August 4, 2015

**RE: Revised Grading Plan (G16-D095E)
National Electric
Albuquerque, New Mexico**

The purpose of this letter is to accompany the enclosed revised grading plan. The plan has been revised to address your written comments dated May 28, 2015. The following is an answer to the corresponding comment number to your letter.

GRADING AND DRAINAGE PLAN

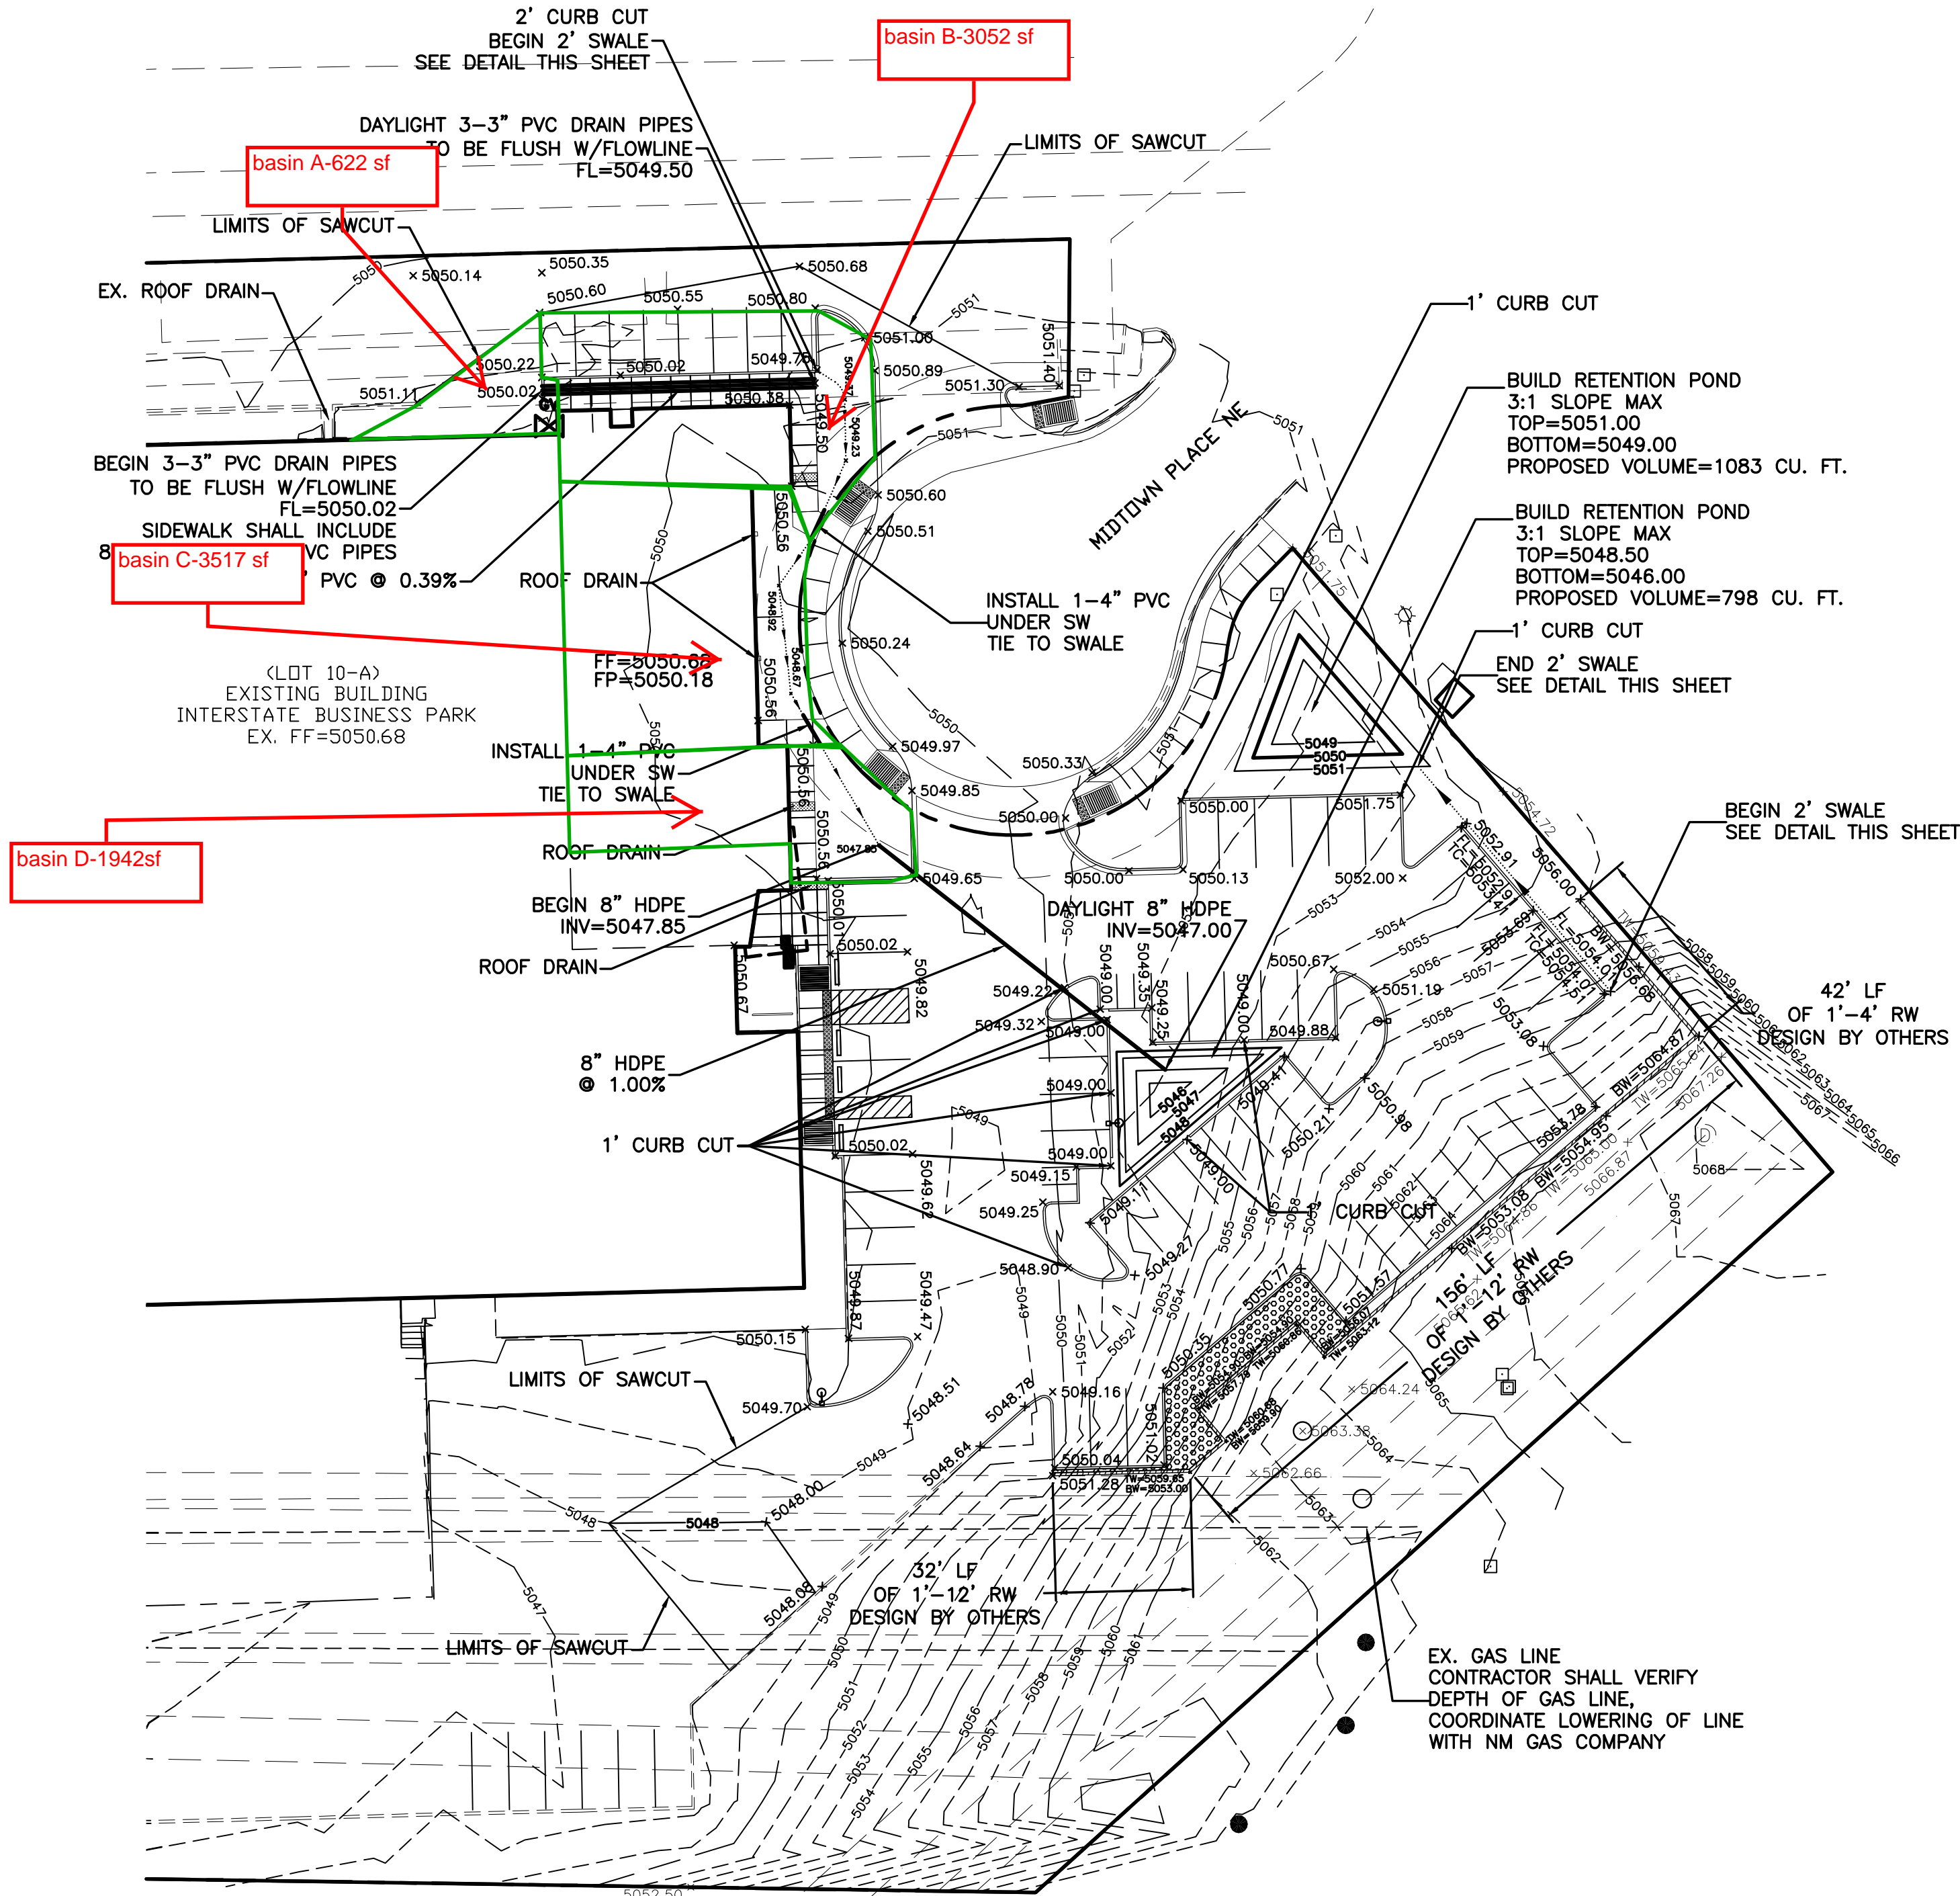
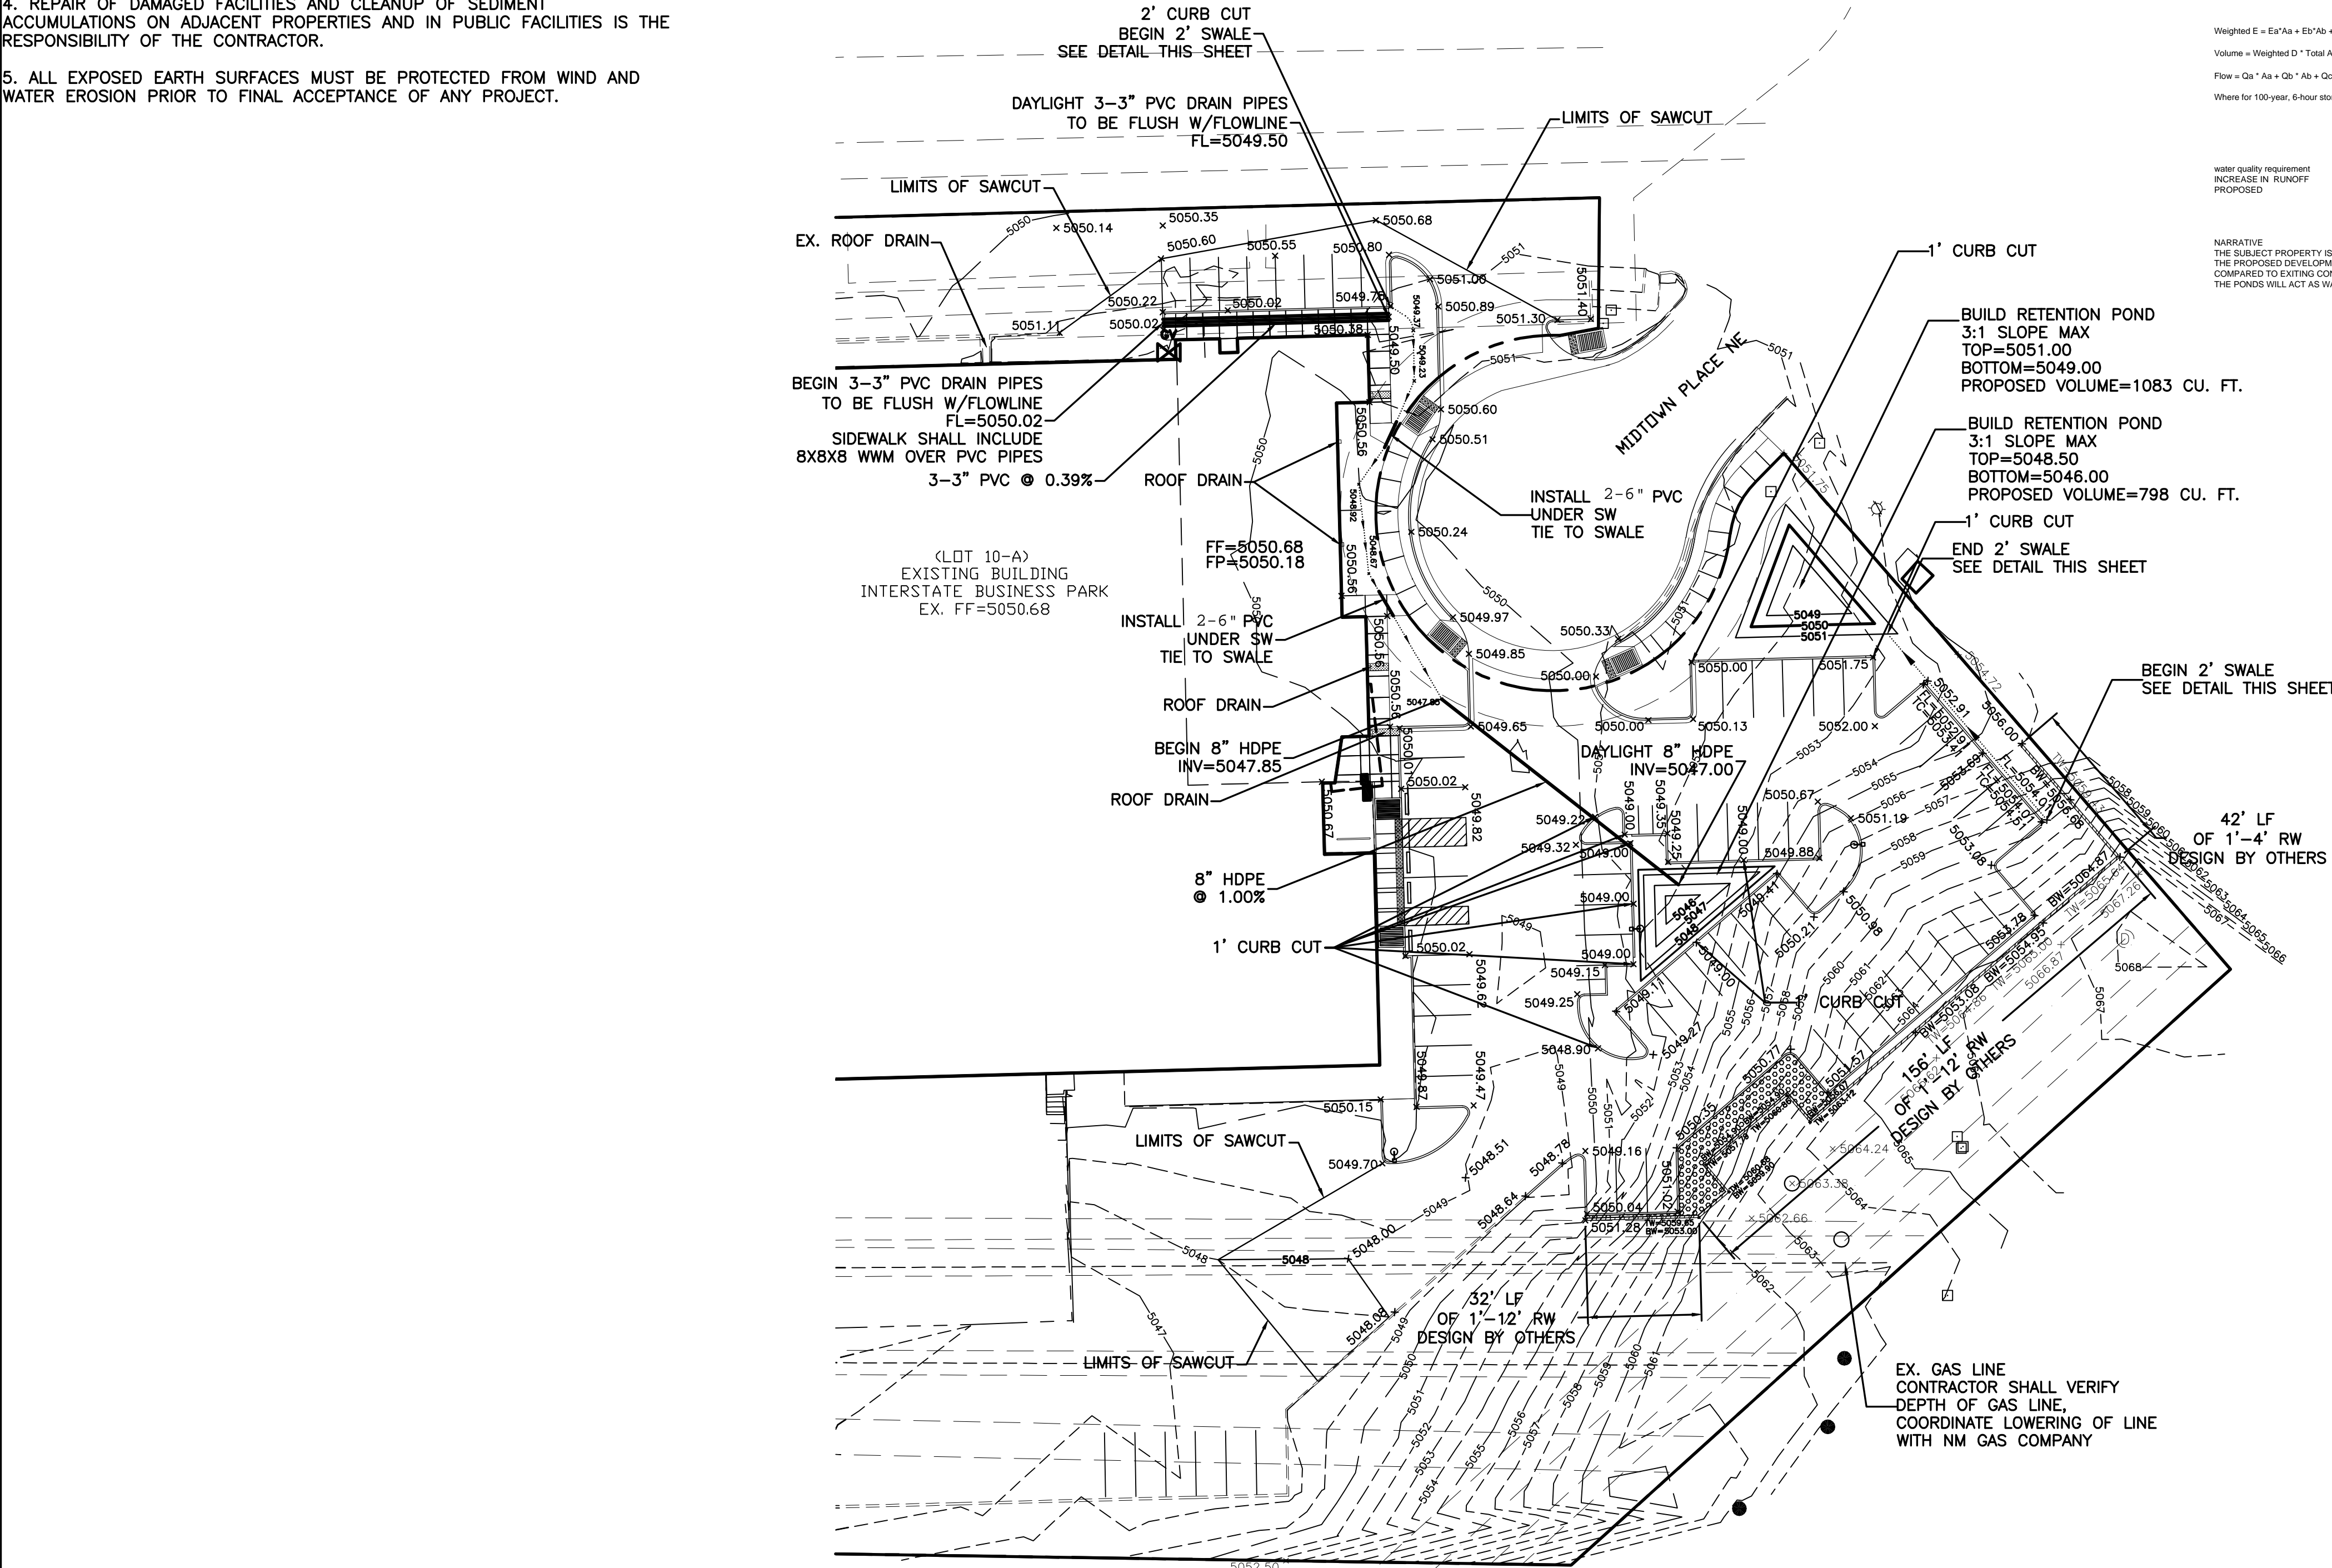
1. We have provided a basin map and labeled project limits
2. We have labeled the pond contours
3. We have shown a swap form the 5049.85 at entry to the pond on north side of site.
4. We have shown the roof drains
5. We have updated the drainage narrative to discuss upland flows and retention volumes.
6. We have labeled the flows in the pips and included calculations for capacity in the
